PROJECT NO. 1002350	APPLICATION NO. 020R501752
PROJECT NAME Buena Ventura	
EPC APPLICATION NO.	
APPLICANT / AGENT MGA Diane Hoelzer	PHONE NO. 828-2200
ZONE ATLAS PAGE K20/L20	
ONE STOP COMMENT FORM LOG

Project Name: BUENA VENTURA ADDITION

DEVELOPMENT REVIEW BOARD TRANSPORTATION DEVELOPMENT Standard Comment Sheet

**Re: Preliminary and Final Plat Approval on
Lot C and D, Block 6, Unit 1, Buena Ventura Addition**

PLAT FOR
LOT C-1
BLOCK 6
BUENA VENTURA ADD.

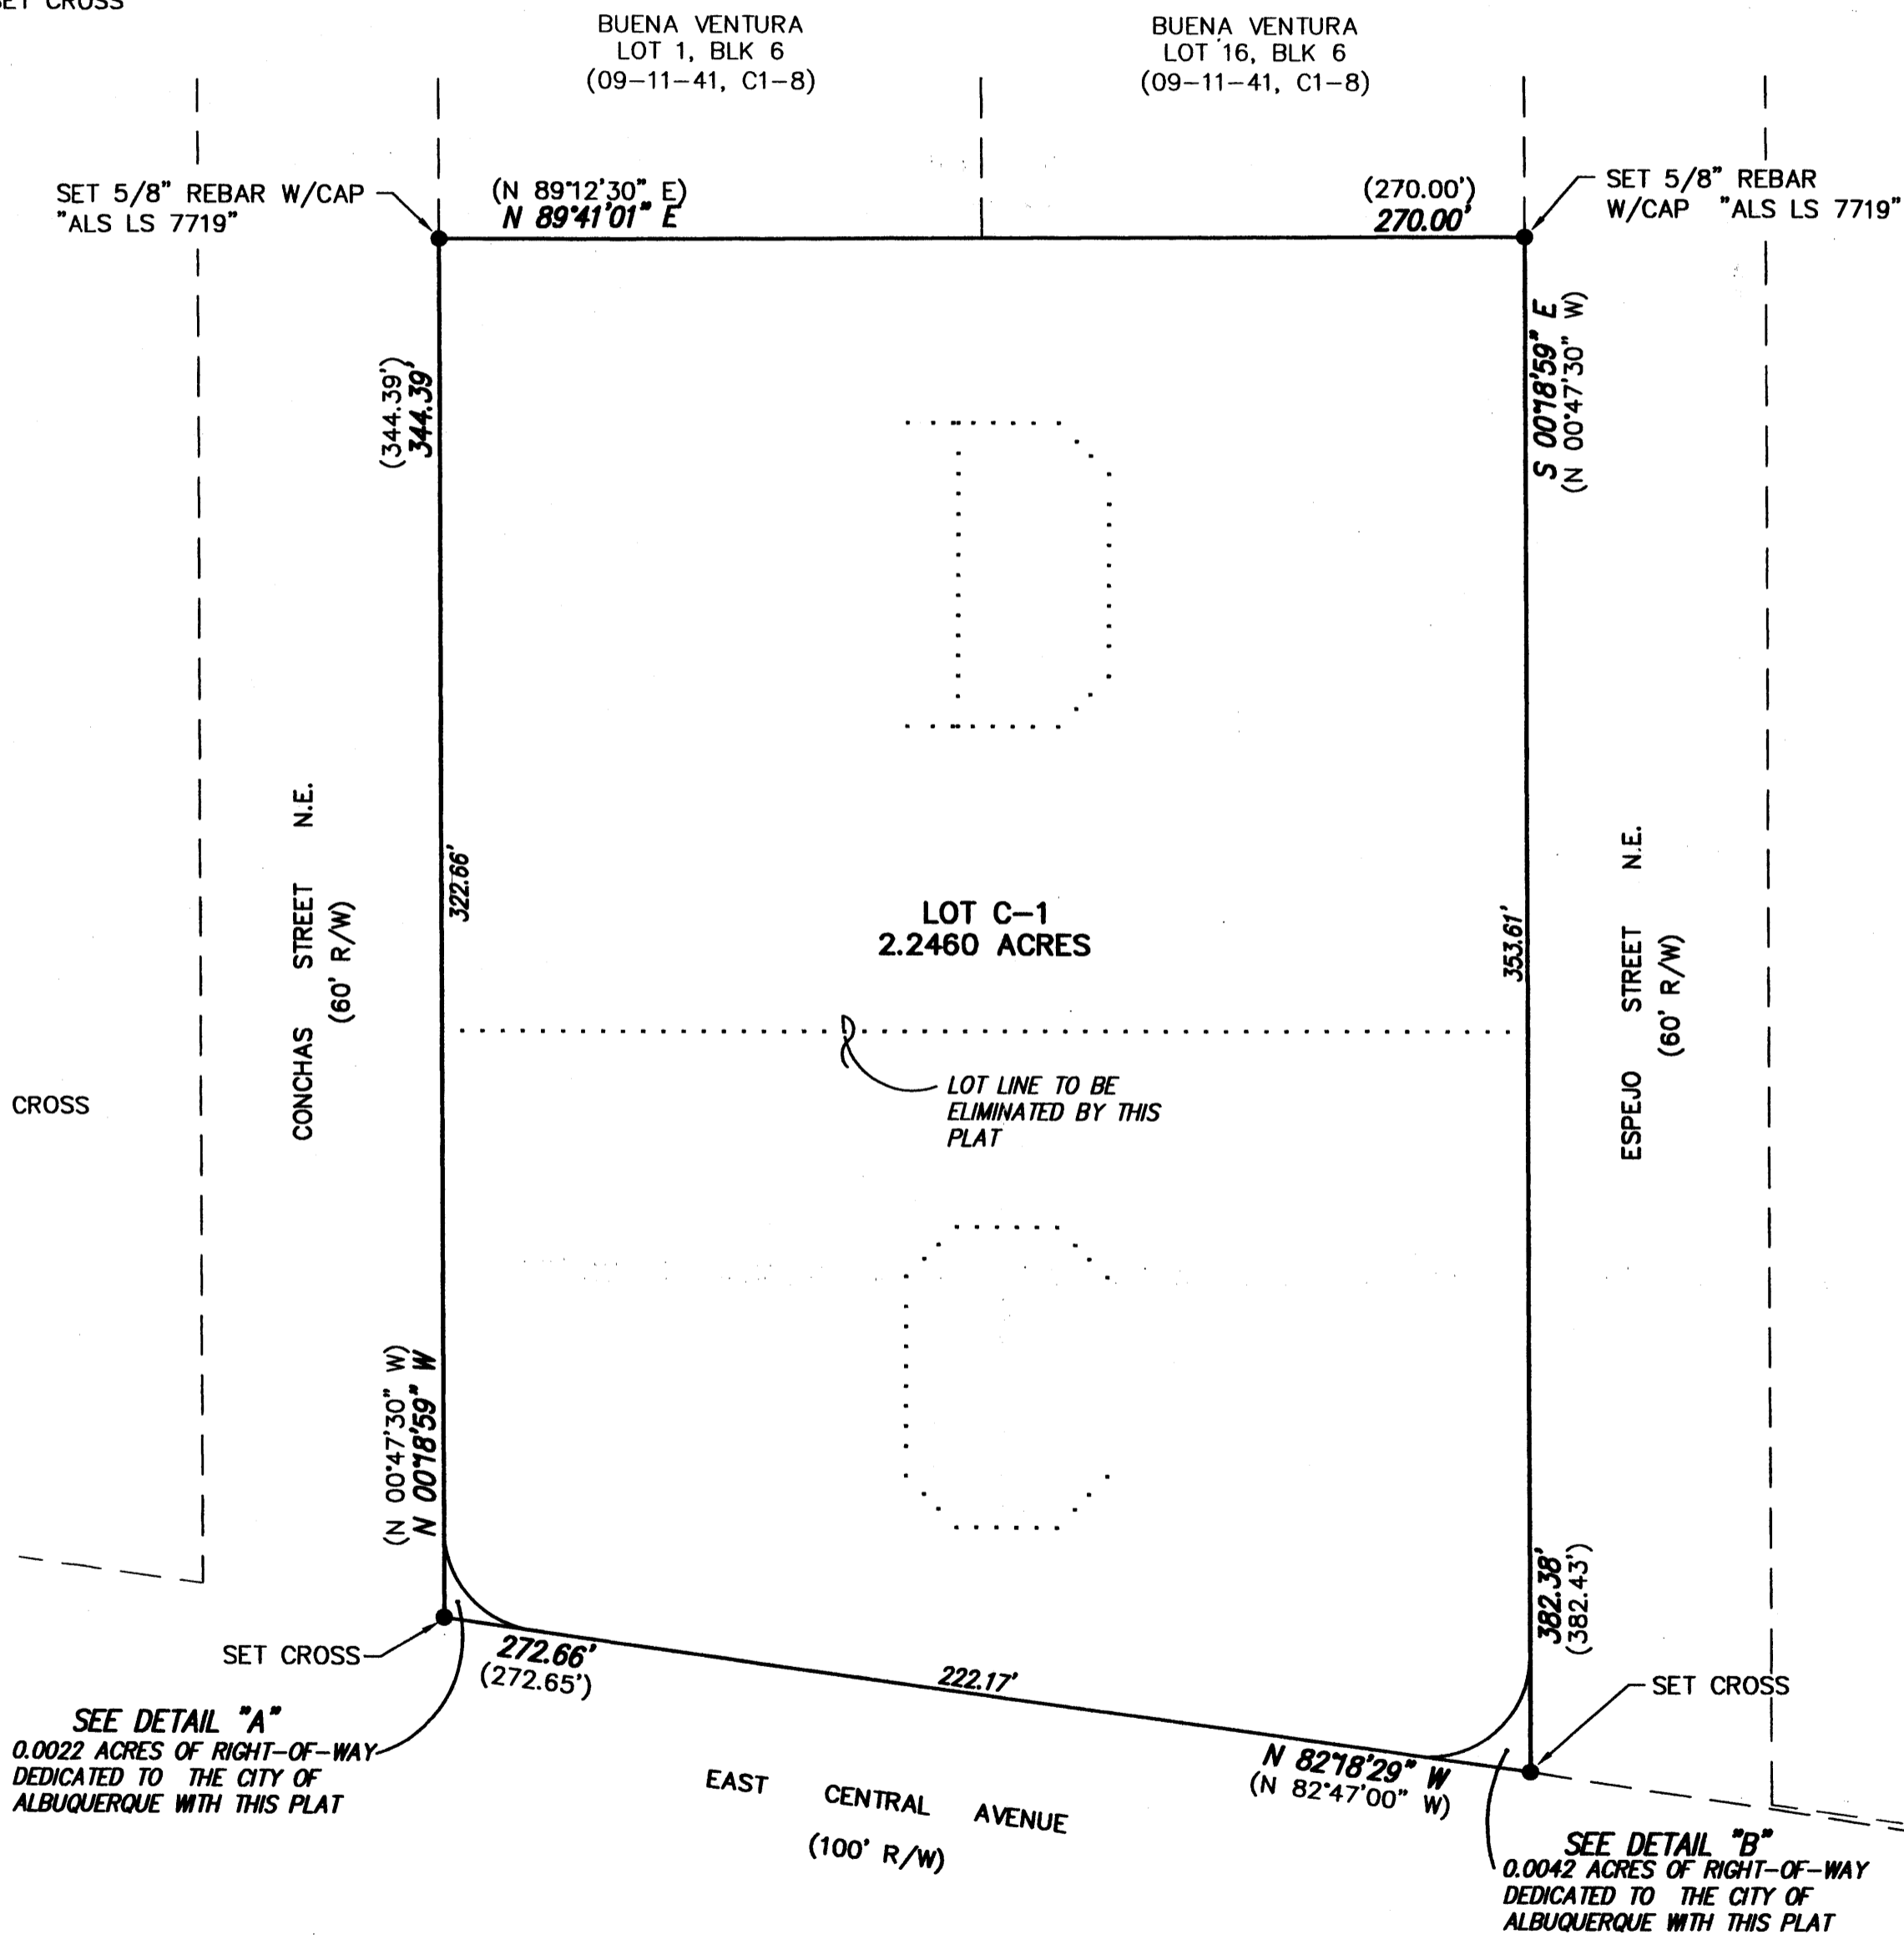
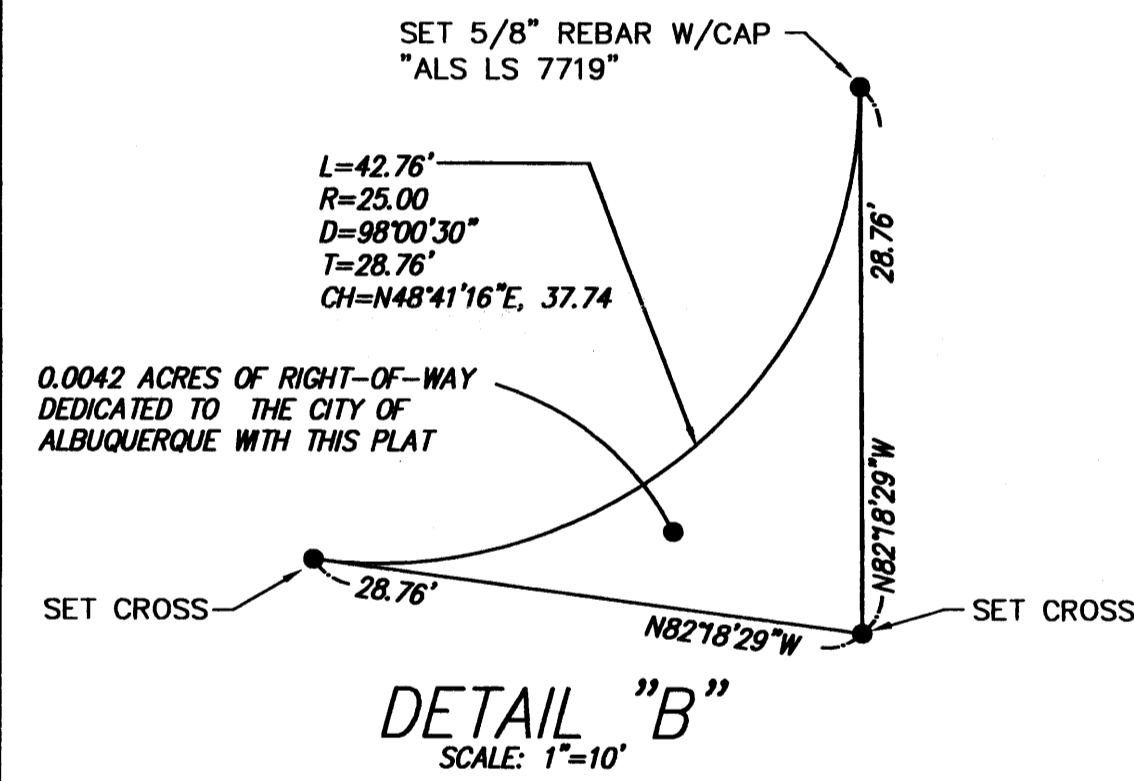
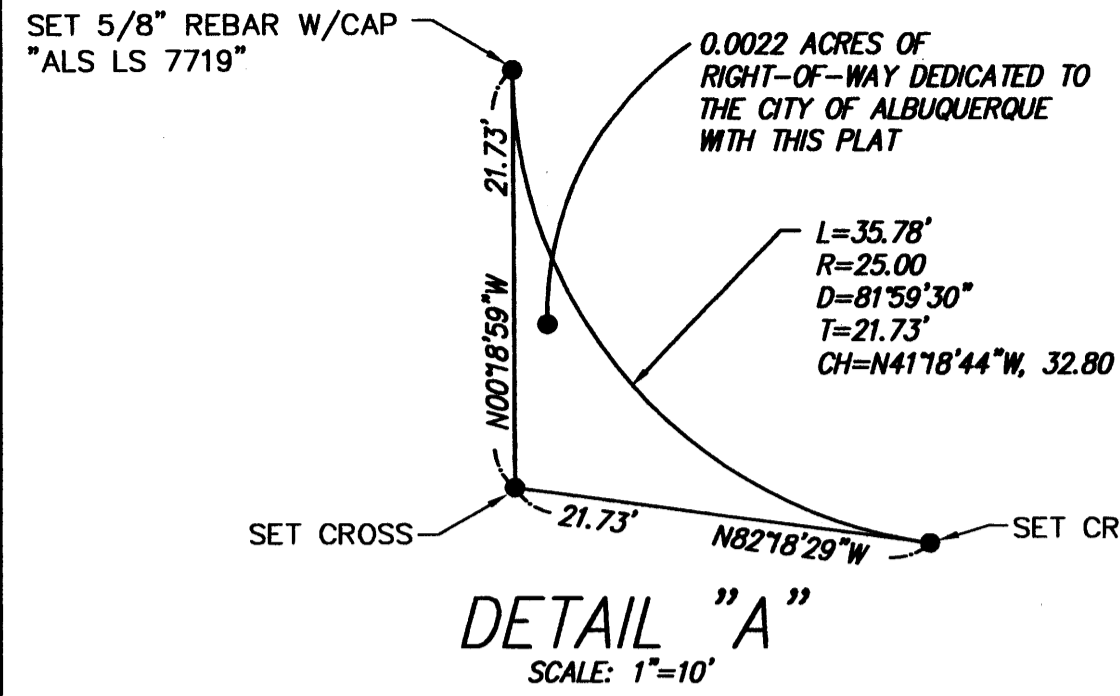
- TRANSPORTATION: 12-02-02
 - Dedication 300' R/W, 10ft from the face of curb
 - on Central
 -
 -
- UTILITIES:
 -
 -
 -
 -
- CITY ENGINEER / AMAFCA:
 -
 -
 -
 -
- PARKS / CIP:
 -
 -
 -
 -
- PLANNING (Last to sign):
 - See comments dated _____
 - EPC comments (name) _____
 - Planning must record this plat. Please submit the following items:
 - The original plat and a mylar copy for the County Clerk.
 - Tax certificate from the County Treasurer.
 - Recording fee (checks payable to the County Clerk). RECORDED DATE: _____
 - Tax printout from the County Assessor.
 - Include 3 copies of the approved site plan along with the originals.
 - County Treasurer's signature must be obtained prior to the recording of the plat with the County Clerk.
 - Property Management's signature must be obtained prior to Planning Department's signature.

No.	Comment
<input type="checkbox"/>	Dedication of right-of-way along Central, 10ft from the face of the curb is needed.
